Application number: 2026/CLD/91870/W	
What is the application for?:	Certificate of lawfulness to convert dwelling to residential institution childre
Address of the site or building:	14, Howard Avenue, Lindley, Huddersfield, HD3 3DJ
Postcode:	HD5 8TE

Type of comment: An objection	
Do you wish your comments to be published on the website anonymously?	Yes
Representation on Application 2026/CLD/91870/W Application: Lawful Development Certificate for proposed change of use from C3 Dwellinghouse to C2 Residential Institution I wish to object to the granting of a Lawful Development Certificate for the above proposal. My objection is not to the principle of providing accommodation for vulnerable people or elderly residents. I recognise that there is an important need for such facilities. My concern is whether this proposal has demonstrated that a Lawful Development Certificate can properly be granted under the Town and Country Planning Act 1990. 1. Insufficient information to establish that the proposed use is lawful A Lawful Development Certificate should only be granted where the Local Planning Authority is satisfied, on the balance of probability, that the proposed use would be lawful.

Existing Site Plan

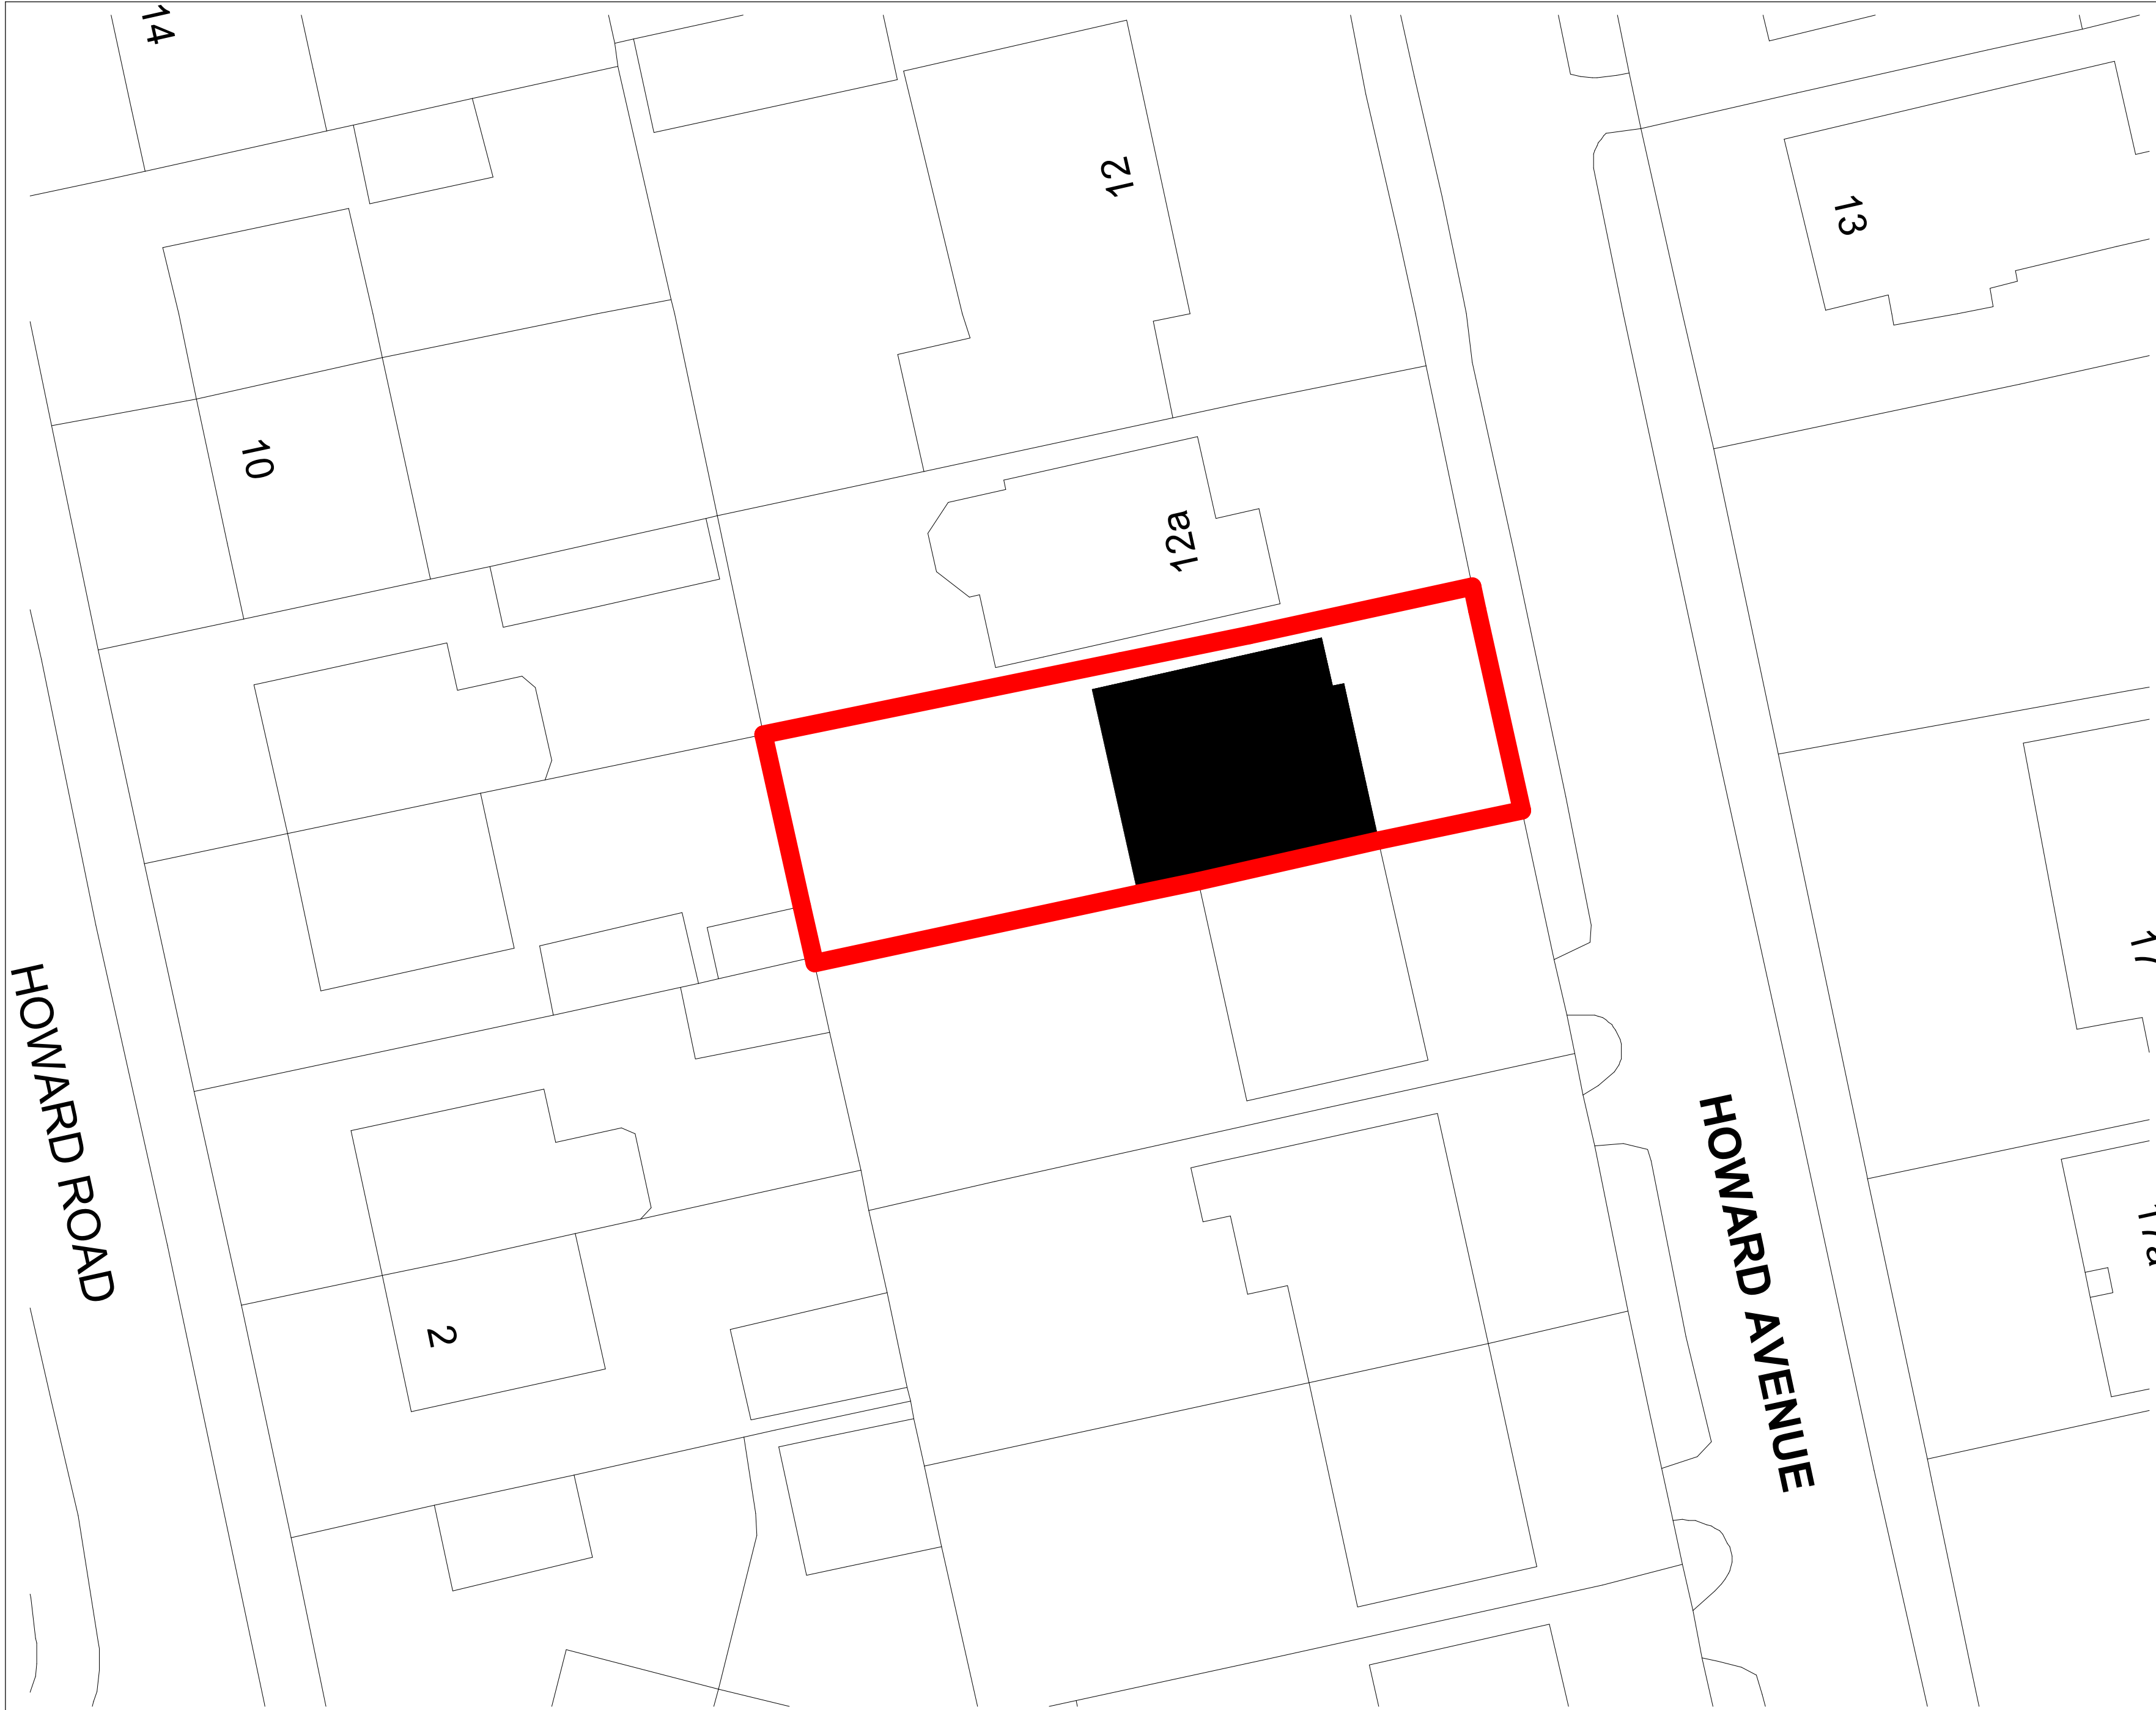
The application states that the property has three off-road parking spaces.

However, residents with direct knowledge of the property consider that this is not an accurate reflection of the practical parking arrangements.

Although three vehicles may physically fit within the frontage, doing so significantly restricts pedestrian access to the property and leaves insufficient space to use the entrance comfortably and safely.

In practice, only two usable parking spaces are realistically available.

No parking layout, vehicle tracking analysis or dimensional evidence has been submitted to demonstrate that three usable parking spaces exist.

Khuram	
14 Howard Avenue, Huddersfield	
Proposed Floor Plan	
Project number	RAD-35-26
Date	20.05.2026
Drawn by	RA
Checked by	RA
20	
Scale	1 : 50

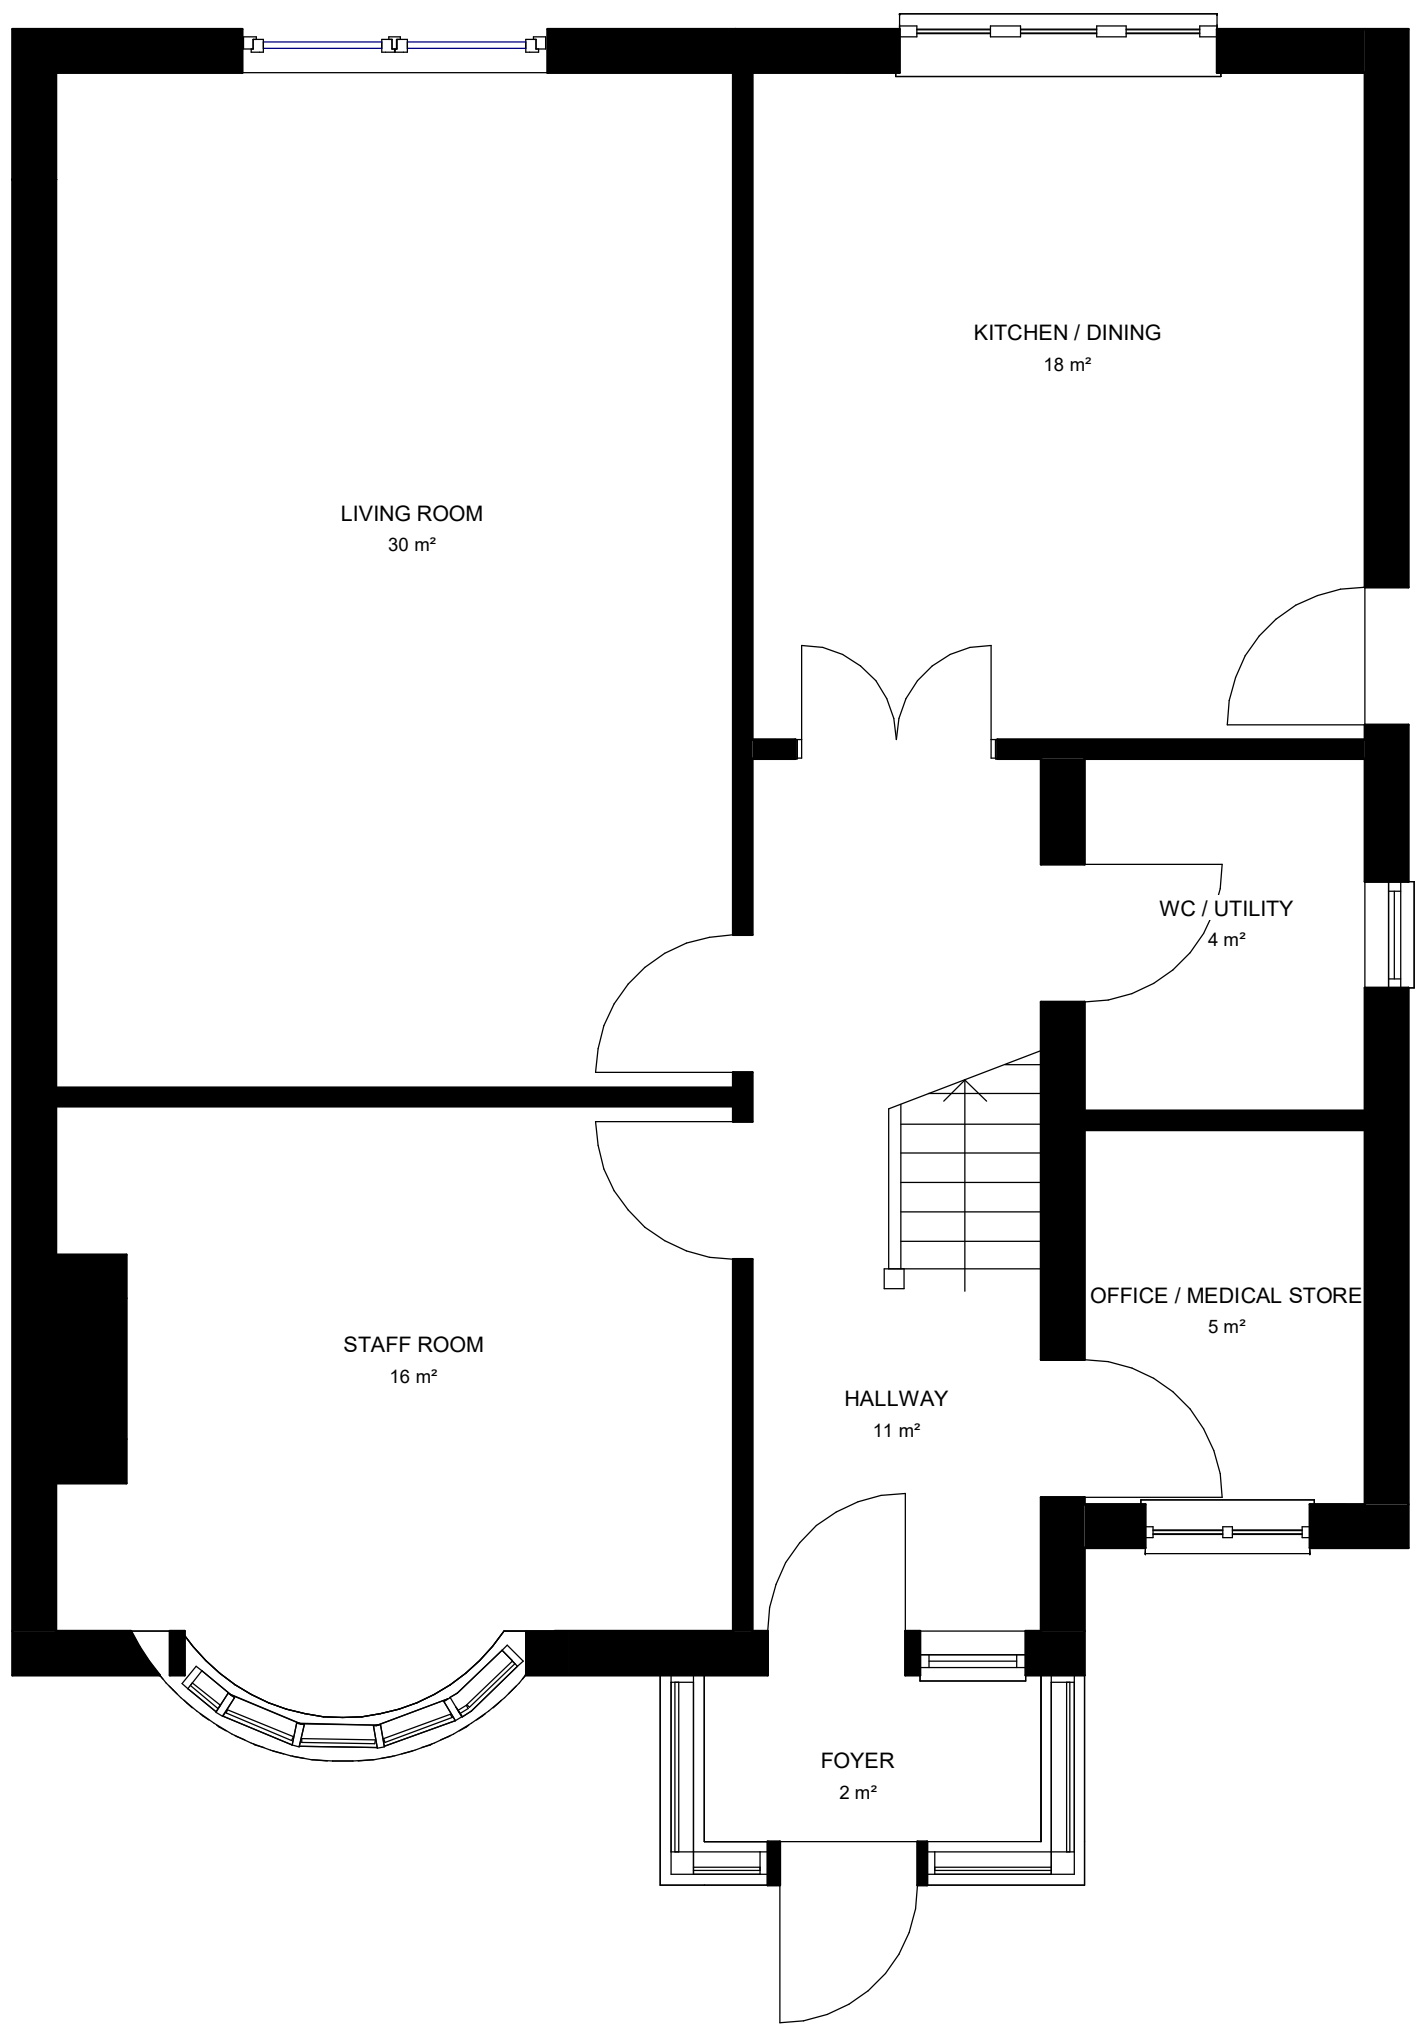
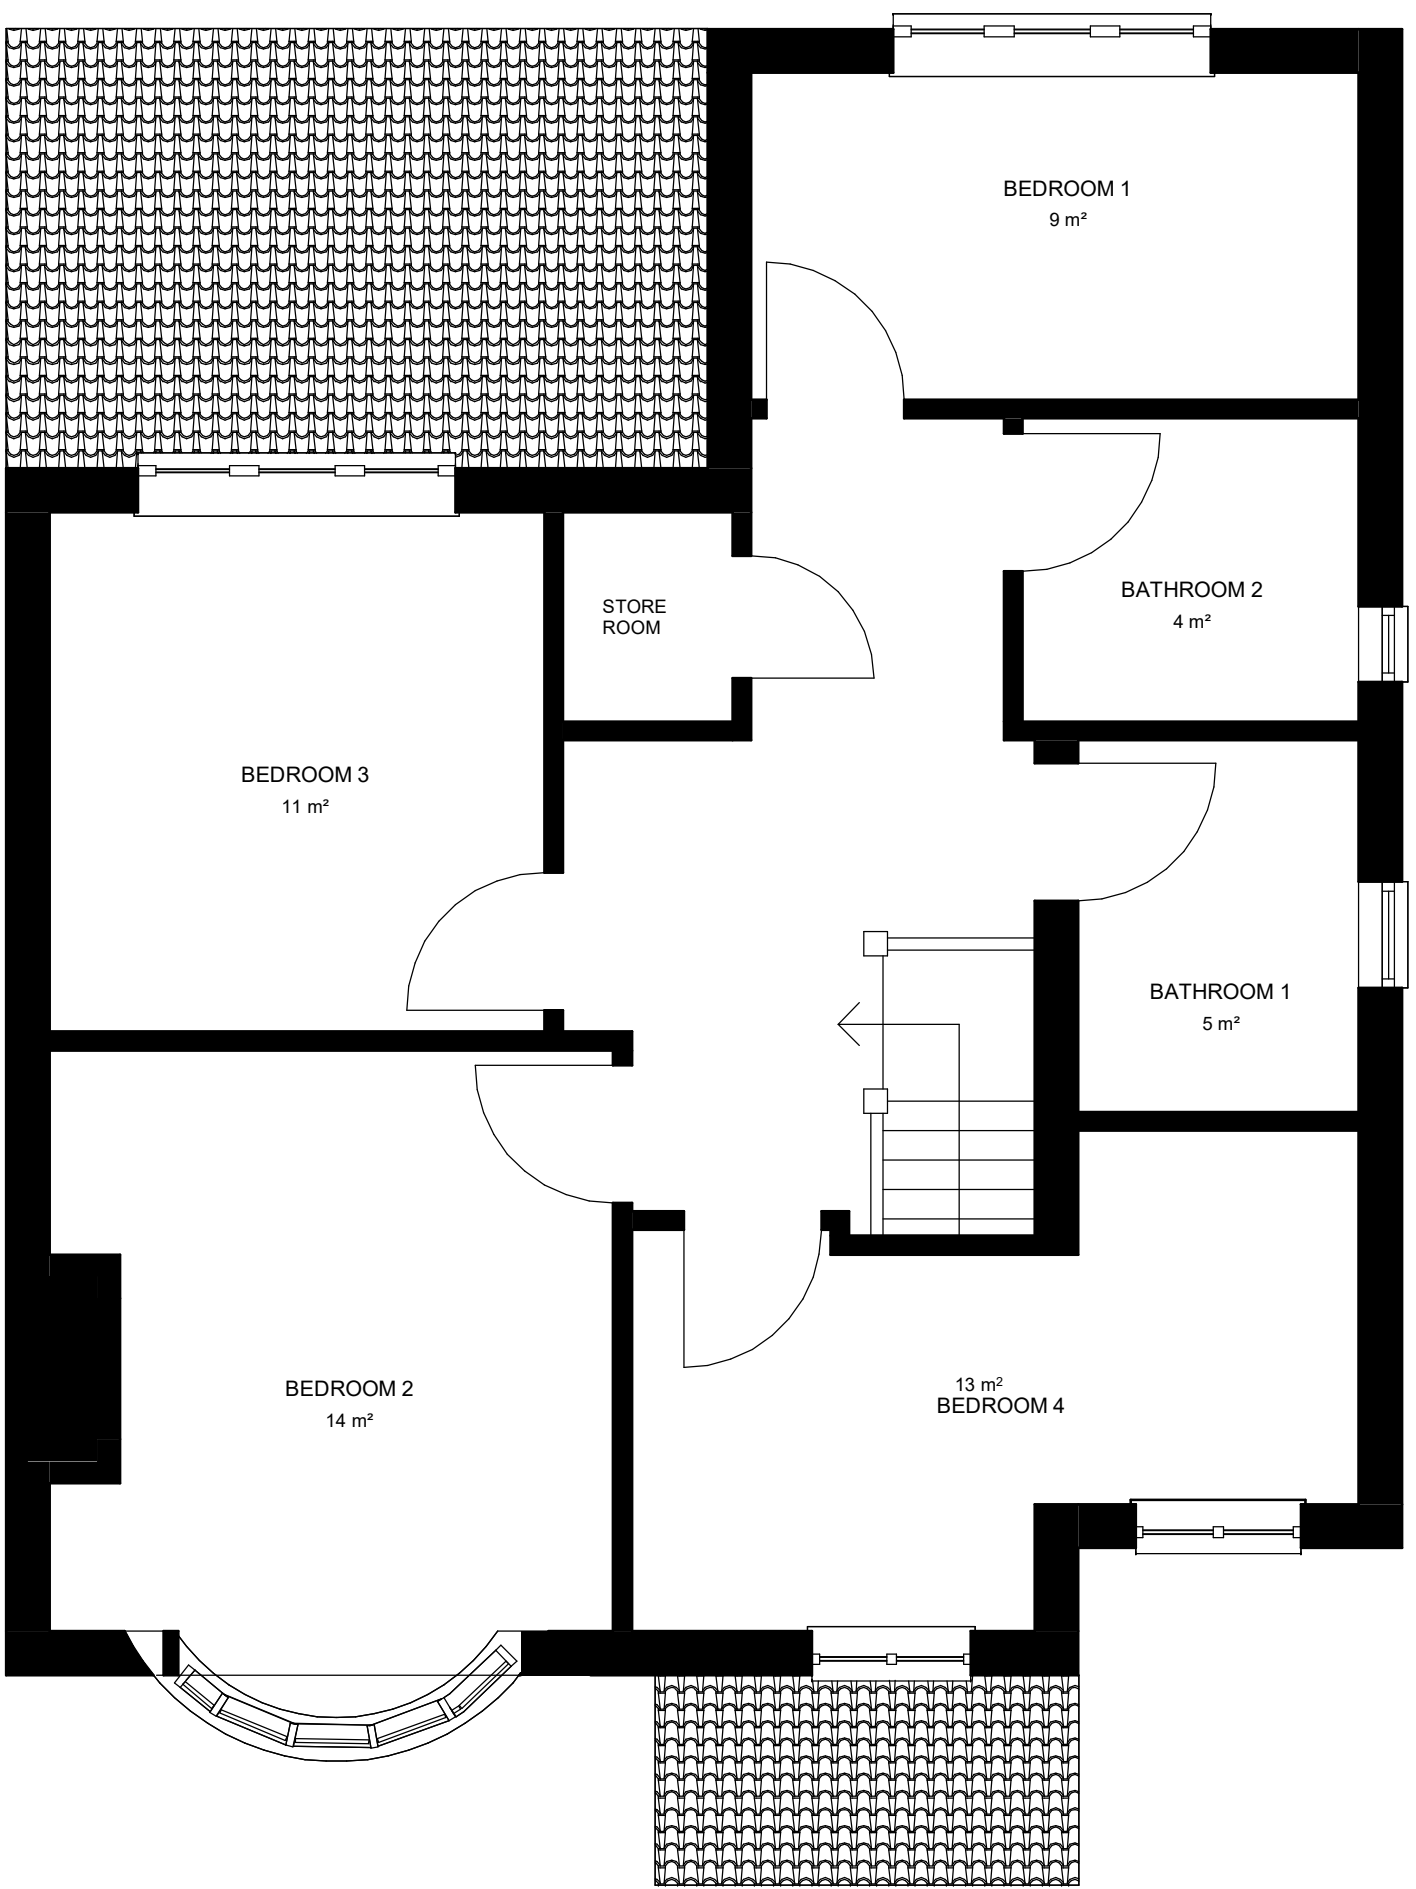
The proposed plans introduce facilities including:

Staff Room;
Office / Medical Store.

These are not simply cosmetic alterations but indicate that the property is intended to operate as a managed care establishment rather than as an ordinary dwelling.

The presence of dedicated staff accommodation and medical storage raises questions about the operational nature of the proposal and whether it represents a material change of use requiring planning permission rather than a Lawful Development Certificate.
